Planning Department
Brennon Williams, Director

June 17, 2020

**Re: Ceja Vista Senior Apartments 10001 Ceja Vista SW
Erosion Sediment Control Plan
Engineer's Stamp Date 6/15/2020 (P09E002G)**

RECEIVING WATERS: OFF SITE POND	
CRITICAL HABITAT: CRITERION "A"; THERE ARE NO CRITICAL HABITATS WITHIN THE PROJECT AREA.	
GPS LOCATION: 35.0231, -106.7446	
CEJA VISTA SENIOR APARTMENTS	
PROJECT TITLE	
ALBUQUERQUE, BERNALILLO COUNTY, NM	
CITY, COUNTY, STATE	
06/15/2020	DATE
C. DURKIN	DRAWN BY

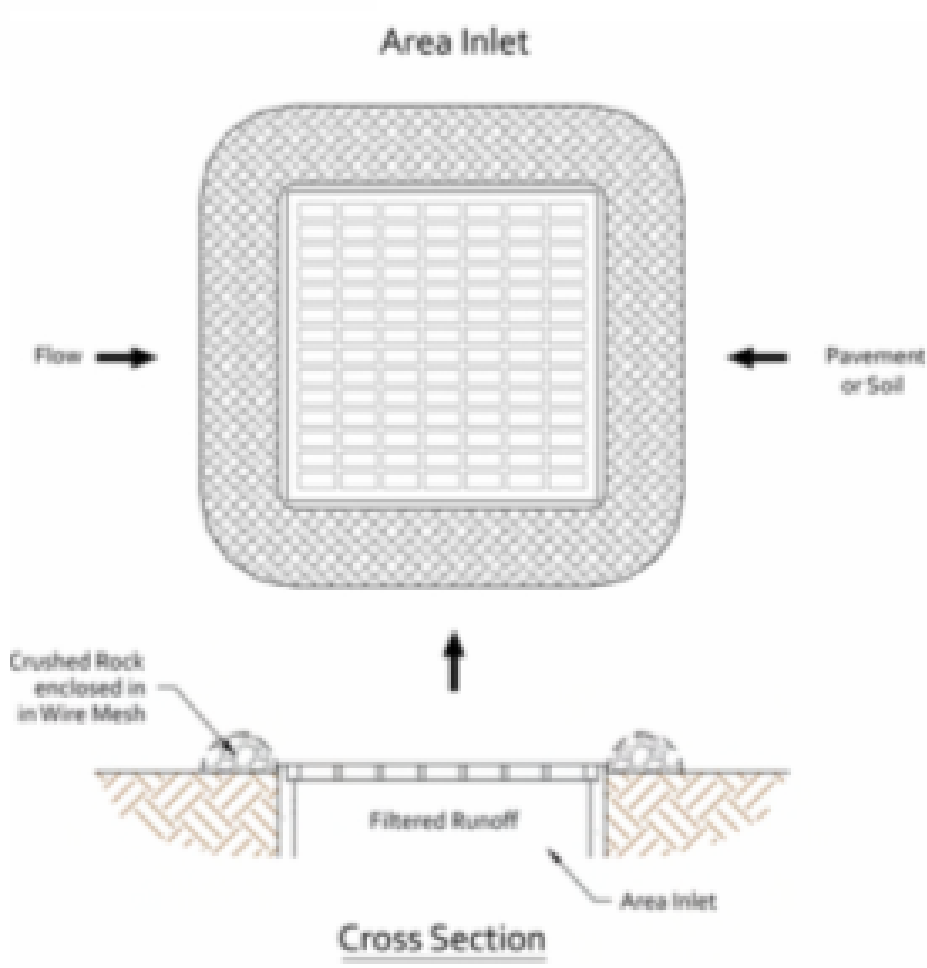
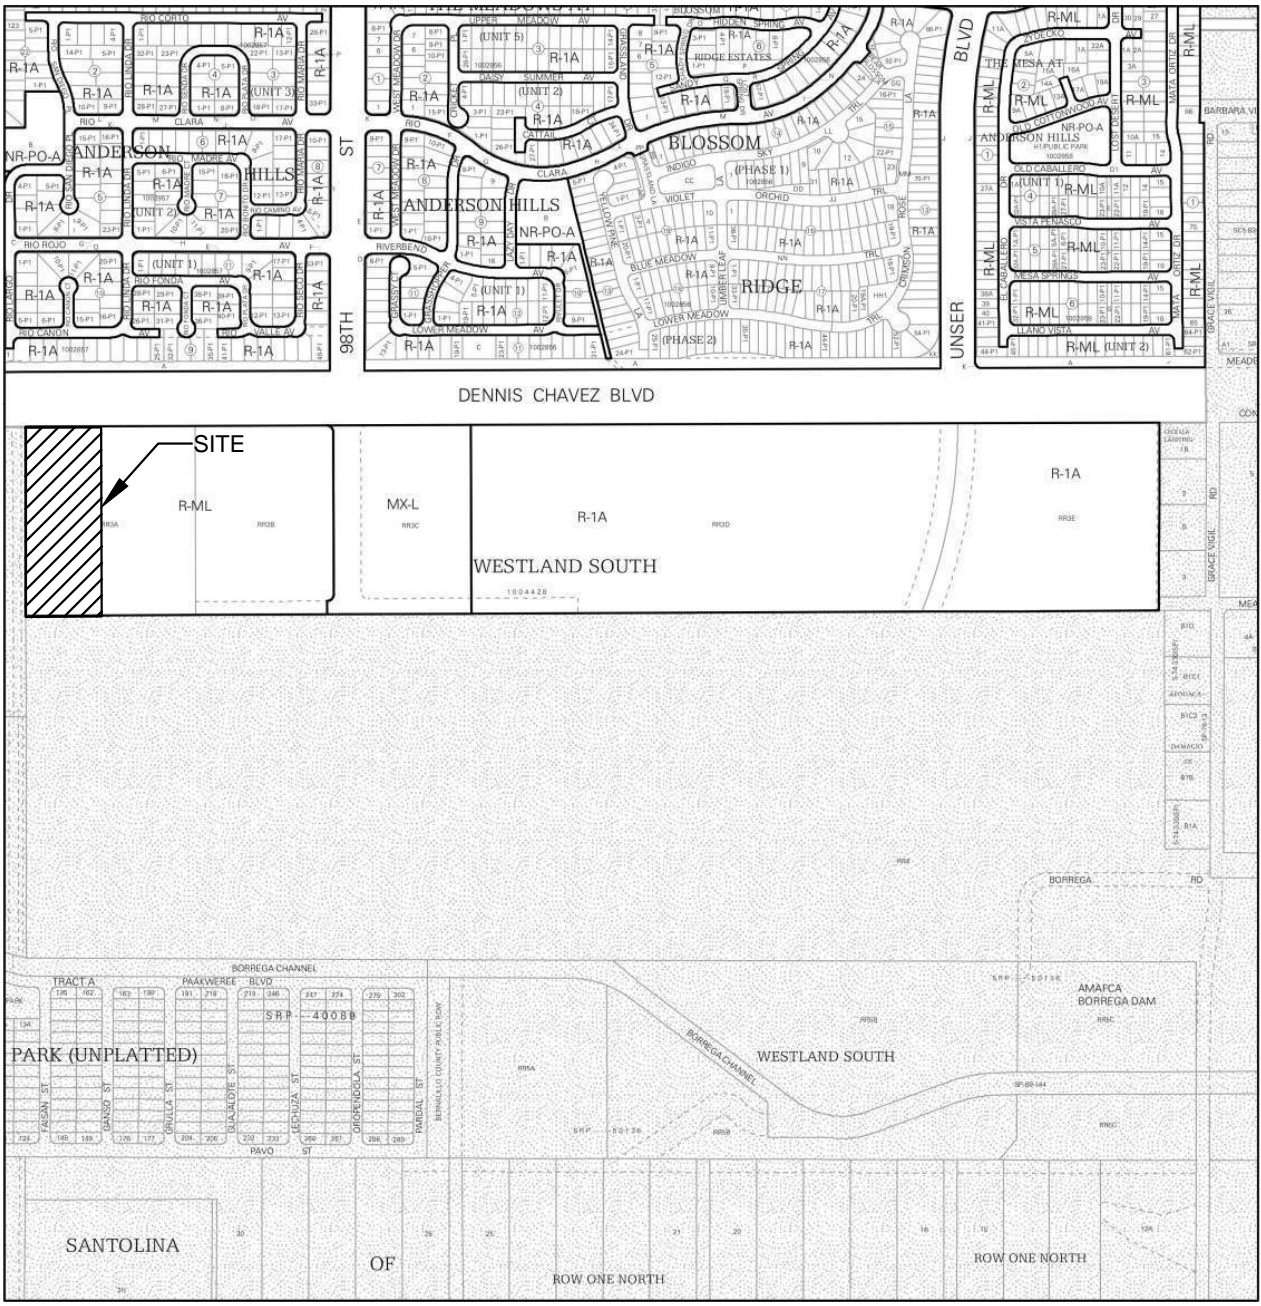
Please see attached approved G&D Plan for Villa de Atrisco Apartments with engineers stamp date 09/27/2018 and note that the finished grade on this site is roughly 8' higher than the finished grade on the property east of this site. The slope east of this site is highly susceptible to erosion. This project may need to construct either a pond or a diversion berm along the east side of this site similar to that shown on the 09/27/2018 plan in order to ensure that no damage occurs to the adjacent site.
